From: Anita Gardner
Sent: 21 June 2017 10:48
To: Planning.Responses
Subject: FW: K/21/17/DOC - Materials Panorama, Golden Acre, Kingston

As requested, please find attached specification sheets of the proposed grey slate roof tiles.
The proposed roof tiles type is SIGA 39 Spanish Natural Slate Blue/Grey.

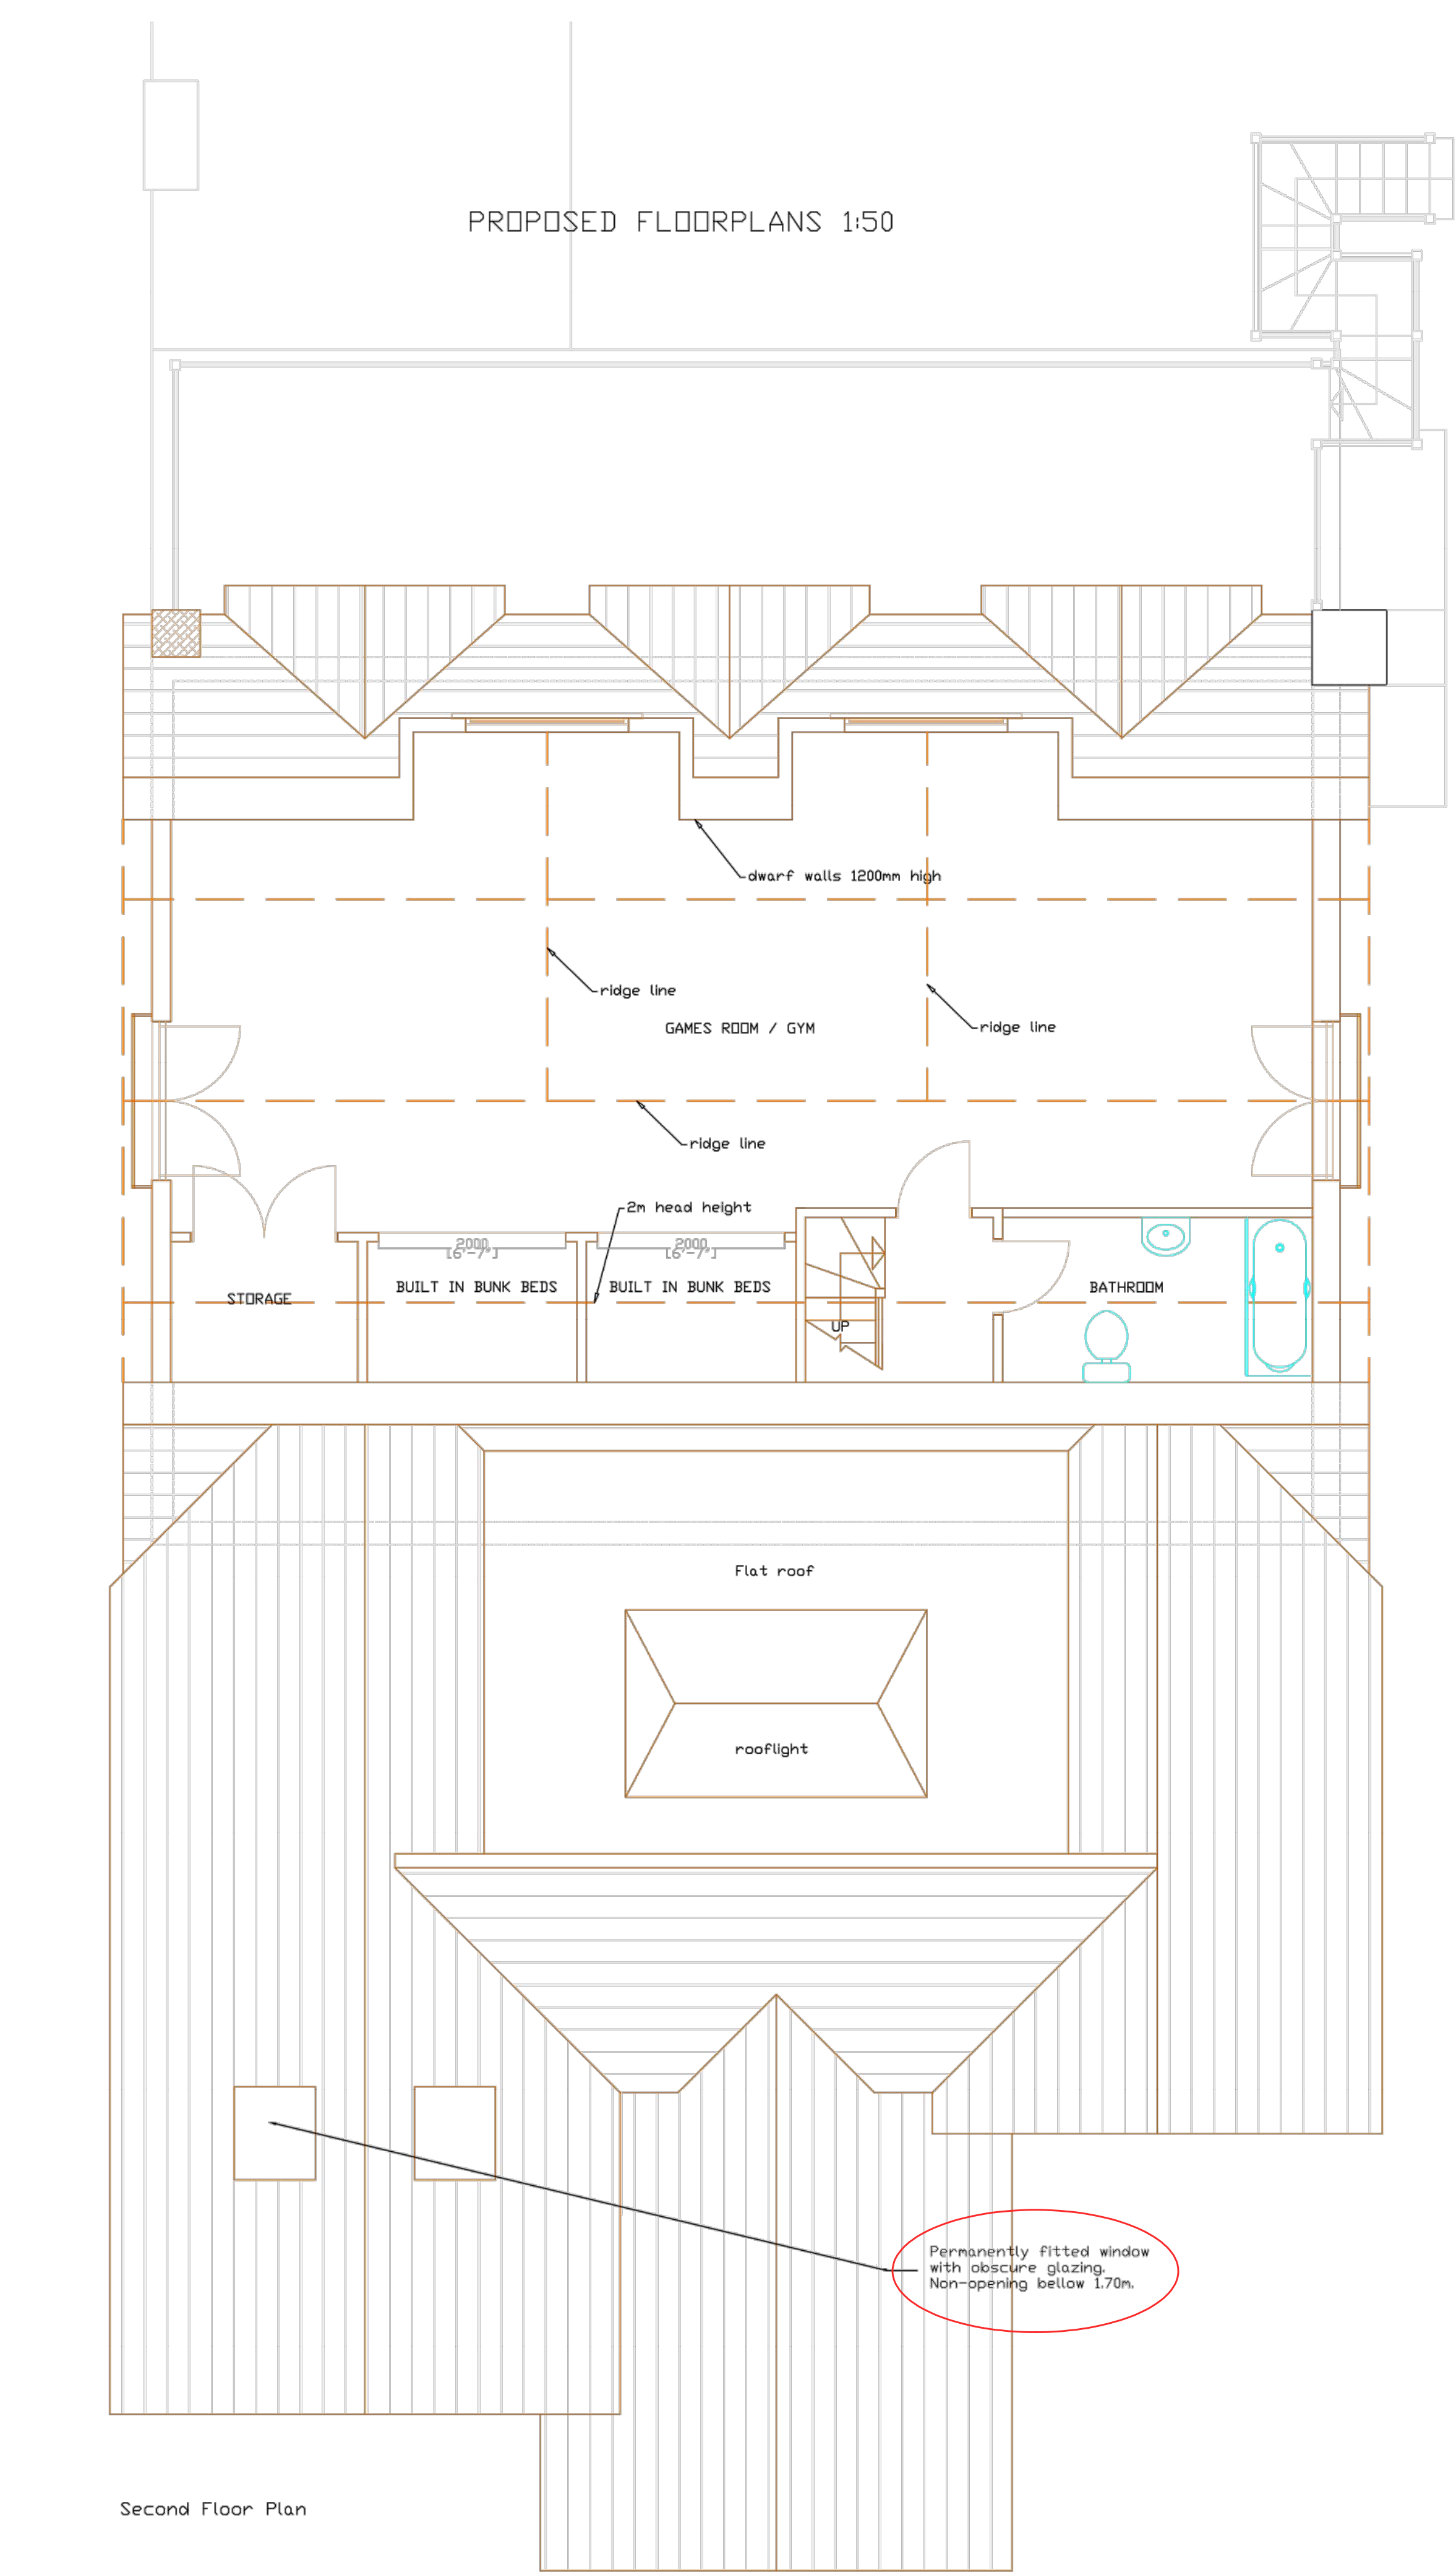
I refer to the above application. Before I can discharge the condition in relation to the roofing material I will require precise details of the proposed grey slate roof ie. manufacturer, colour. I would appreciate receipt of further details within the next 7 days.
